ASSESSMENT REPORT

Building R1, Barangaroo South SSD 6513 MOD 2

The application seeks approval for minor design amendments at the ground level and at the rooftop level of the building.

drawing title
Plant Room Roof Plan

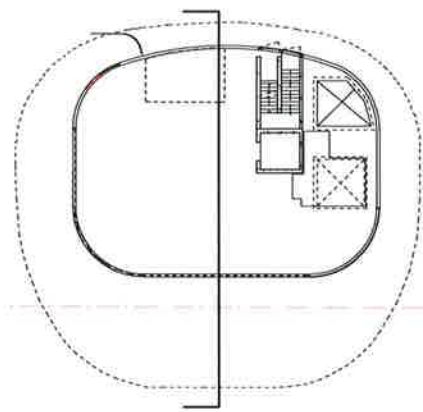
The Applicant seeks approval to reconfigure the cladding treatment of the rooftop plant room to further conceal the plant room from view. The Applicant also seeks to reconfigure the design of the handrail at the rooftop of the building. The modifications are proposed to further improve the aesthetics of the approved building.

The Department accepts the modifications will not be visible from the public domain and will further conceal the visual appearance of the plant room, ensuring it reads as being an integral part of the design of the rooftop of the building.

On this basis, the Department supports the proposed rooftop alterations.

drawing number
BR1-ASK-12-00-21

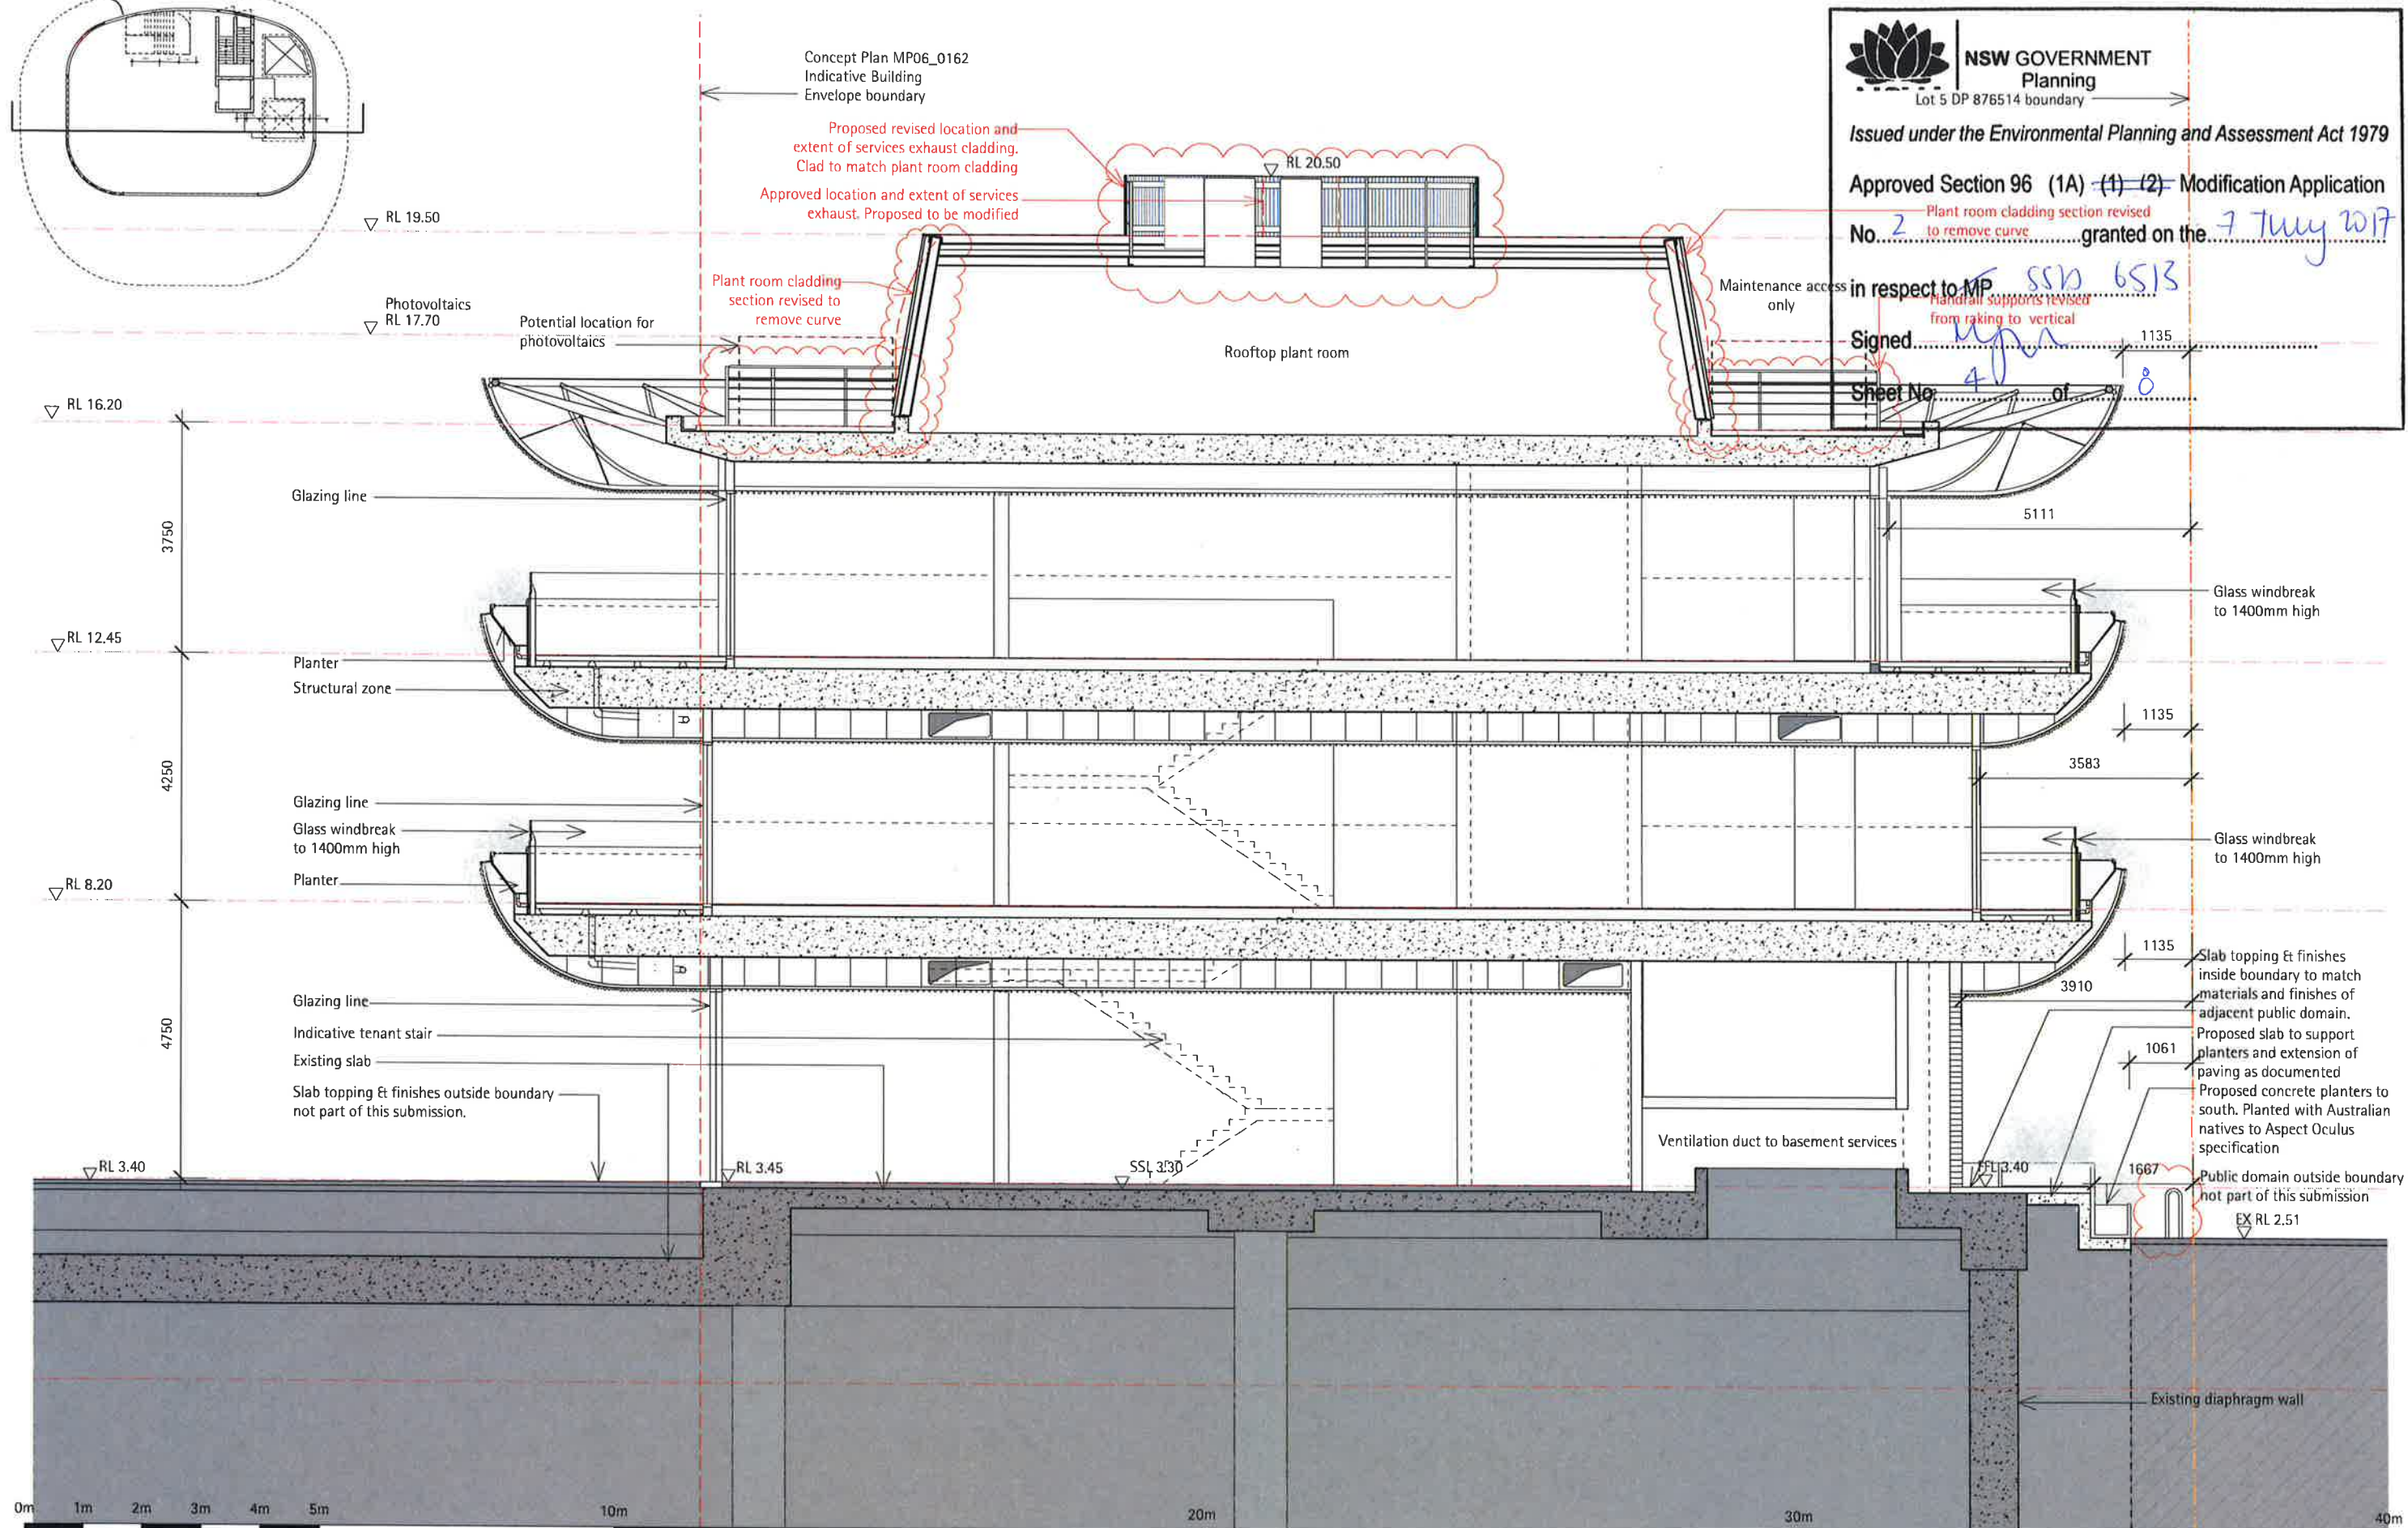
The Applicant seeks approval to relocate the entry door along the north-eastern elevation of the building and alter handrails associated with the stairs at ground level along the southern elevation.

The Department notes the entry door is being relocated only 1 m to the east of its current position and will not therefore not be perceptible nor materially alter the external appearance of the ground level façade of the building. The alterations of the handrails are similarly minor and will not give rise to public domain or accessibility issues.

The external ground level alterations are accordingly supported.
